PLANNING CONSULTATION RESPONSE

Application No	2026/0347
Proposal	Change of use to utilise a proportion of an existing outbuilding (Use Class C3) as a wellbeing retreat and meeting space (Use Class Ee and Ec2). Including minor alterations
Address	Copster House, Rag Lane, Thurgoland, Sheffield, S35 7BA
Date of Consultation Reply	04/06/26
Consultee	Highways DC

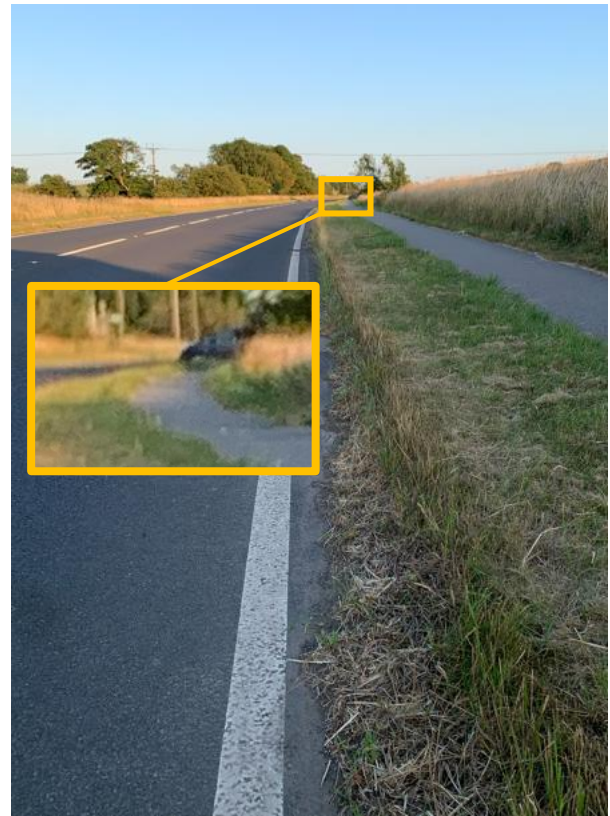
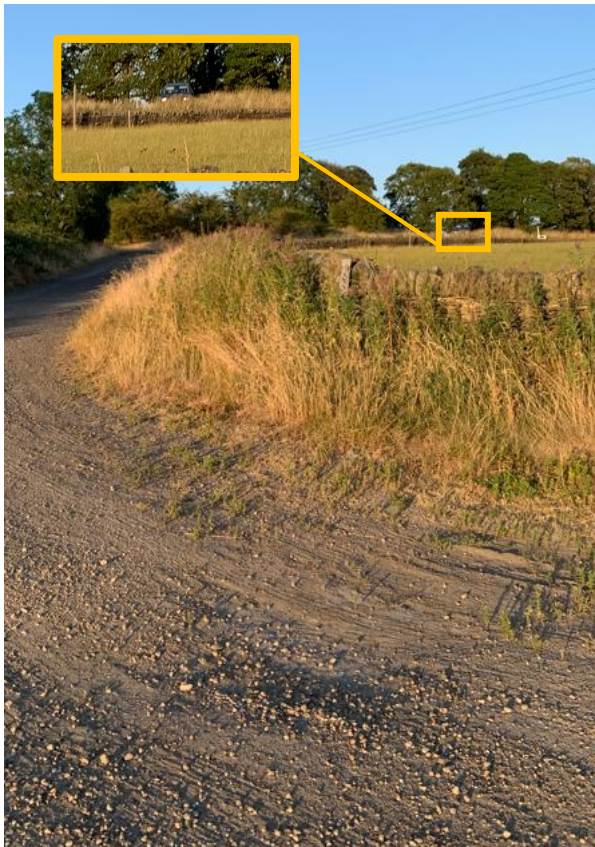
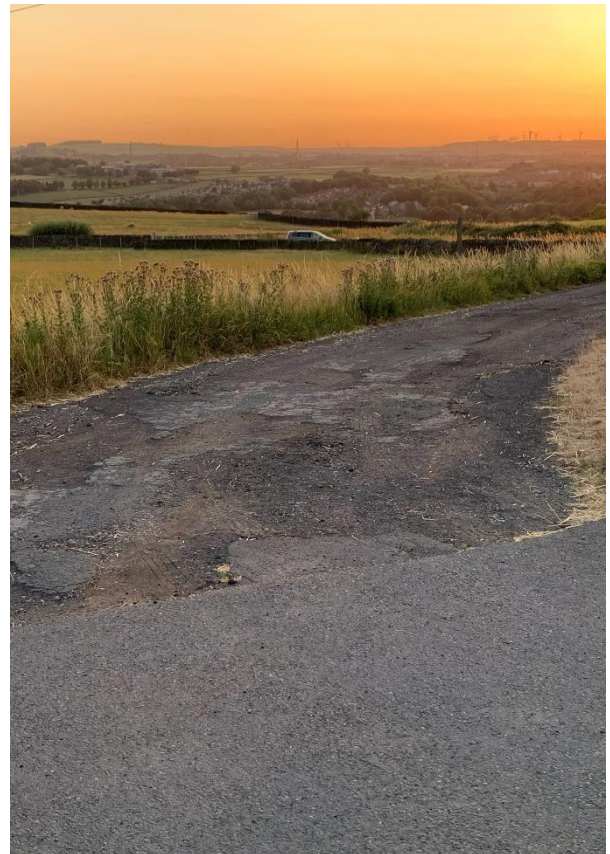
Following pre-application advice, the applicant has clarified that access from the site car park will be taken from Copster Lane onto Rag Lane, rather than from the other established access directly onto Rag Lane in close proximity to Roper Lane. Whilst this is the preferred route when considering highway safety implications, the submitted visibility splays are drawing incorrectly. Similarly, the photographs taken to demonstrate the line of sight to the junction are not from the nearside kerb.

Drg No: CK 005 Amended 7 July 2026

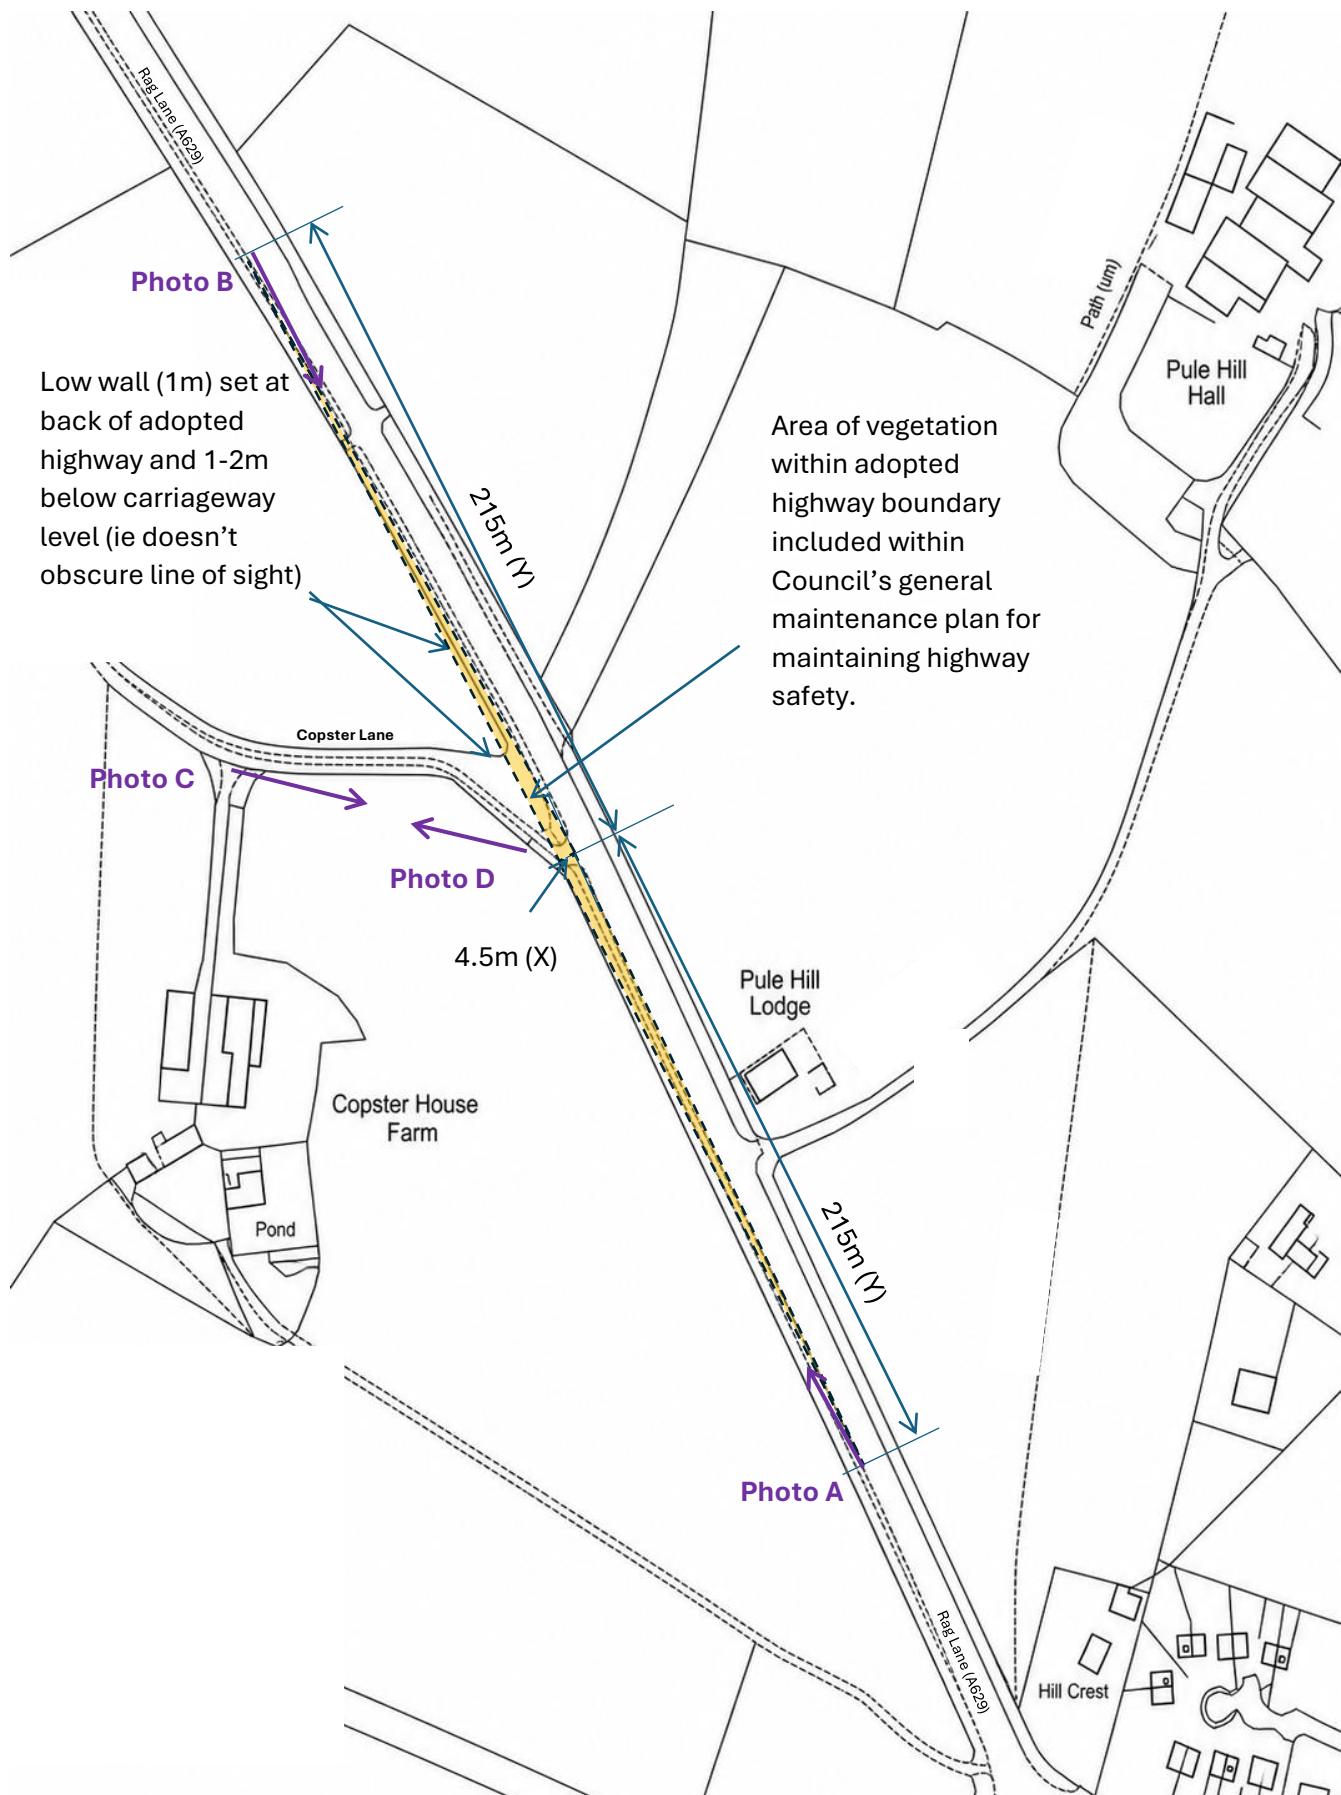
HDC officers would therefore ask that the visibility splays are redrawn to be commensurate with the advice set out in Section 3 of document CD 123 Geometric Design of At-Grade Priority and Signal-Controlled Junctions whereby sight lines are shown from a set-back of 4.5m to the nearside kerb line in each direction. As Copster Lane is also adopted highway, visibility splays should also be demonstrated from the site access onto the Copster Lane.
